Re: Porch Plan Review & Structural Specifications

104 Sherman Pines Dr, Fuquay-Varina, NC 27526 - Harnett Co.
Project #: 23091

Arrow Design, PLLC was contacted on 6/26/23 and was requested to review a proposed second floor porch addition plan and provide any structural specifications that may be required. Below is a summary of the items Arrow Design, PLLC evaluated. All direction references are based on viewing the structure from the rear of the home.

Ledger Attachment Detail

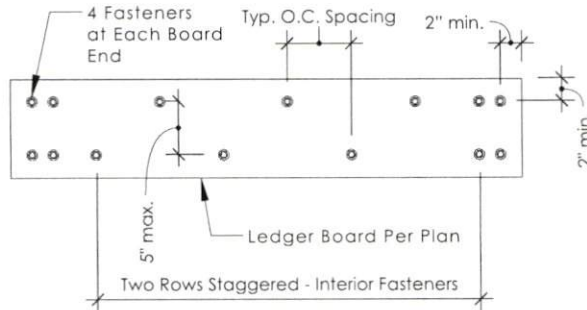
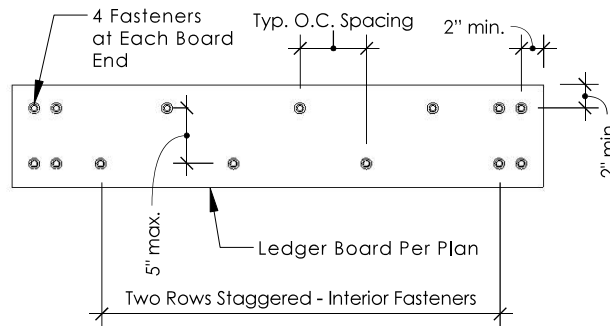
3. Required Deck Floor System Framing:
 - Deck floor joists shall be P.T. 2x10's @12" O.C.
 - Attach a 2x12 ledger board to the existing house using the ledger attachment detail at the end of this report.

"Y" Bracing Detail

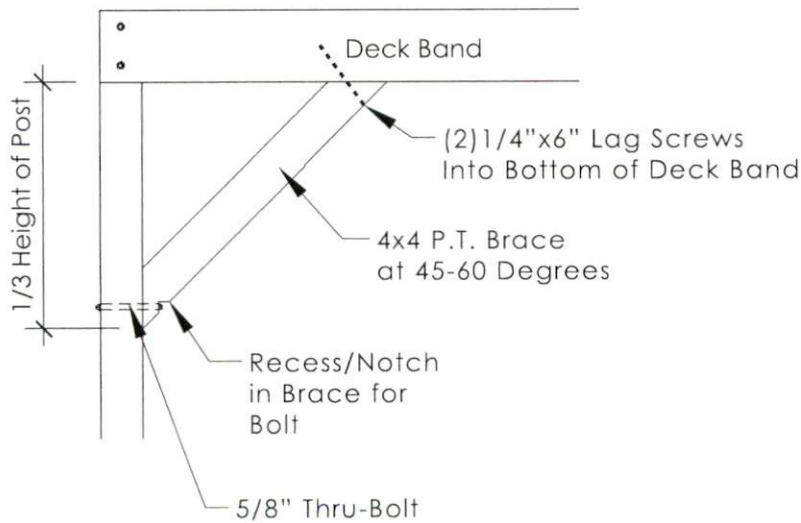
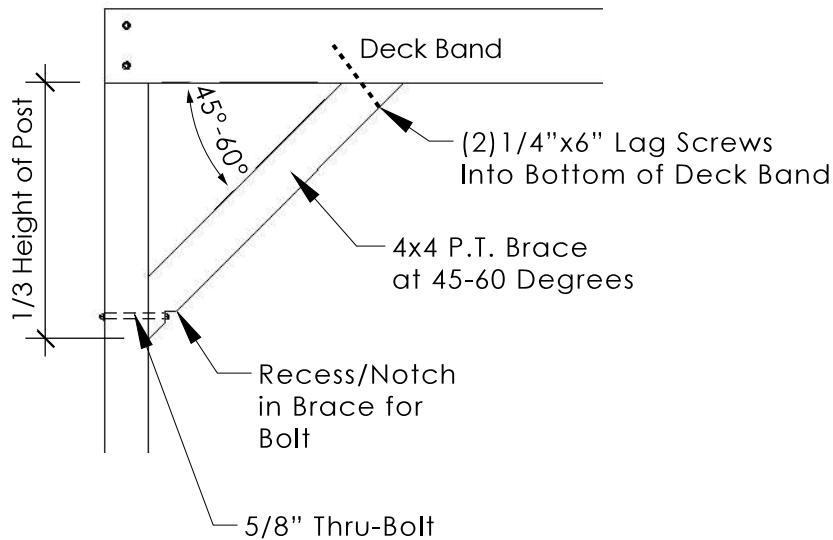
- 8x8 P.T. support posts shall have "Y" bracing attached at each corner parallel with the rear wall of the house. Refer to the "Y" bracing detail attached at the end of this report.

Footing Detail

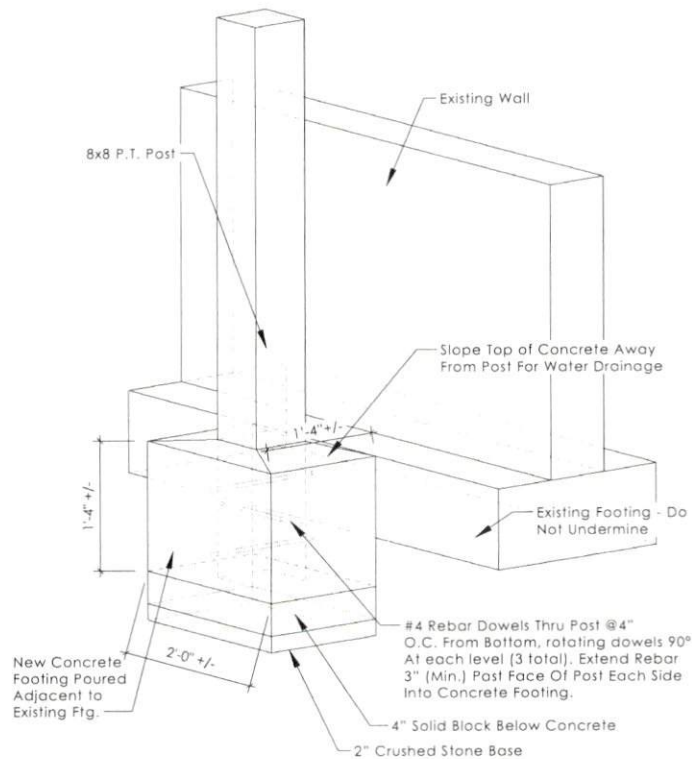
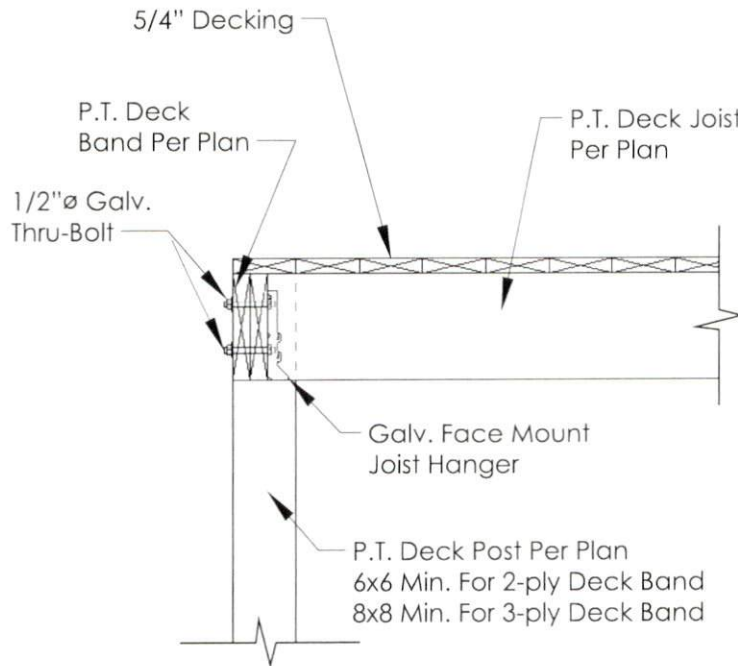
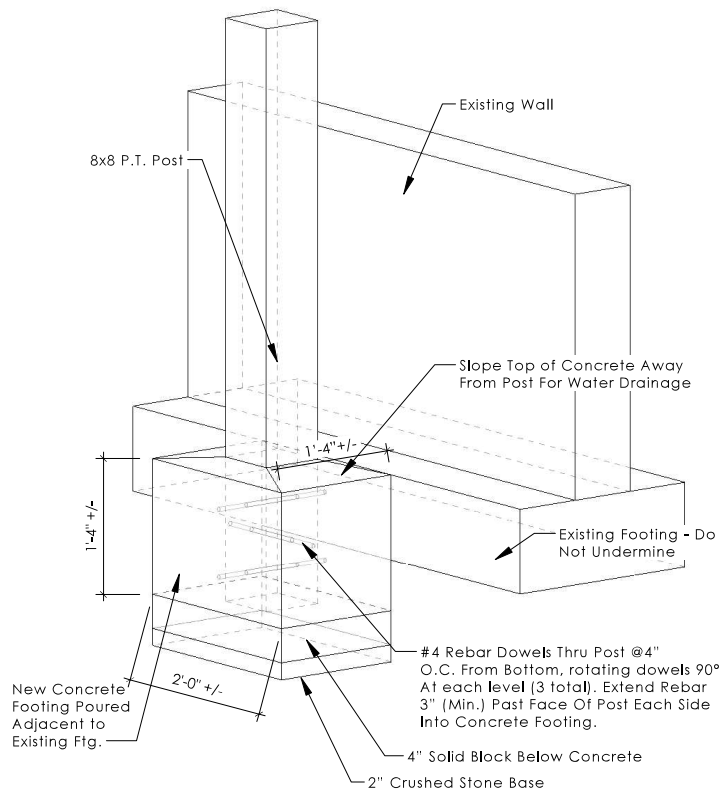
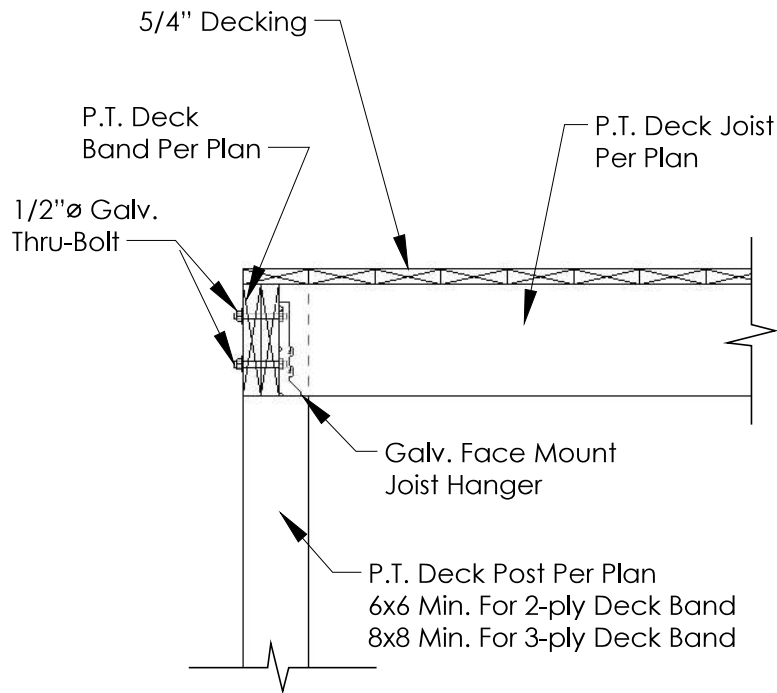
- The 8x8 post posts shall be supported on 24"x24"x10" plain concrete footings. An existing footing exists adjacent to the location of the post bearing. This footing may be expanded according to the footing expansion detail located at the end of this report.
- Attach the posts to the new footing using a SST ABU88Z, CPT88Z, or equivalent product post base.
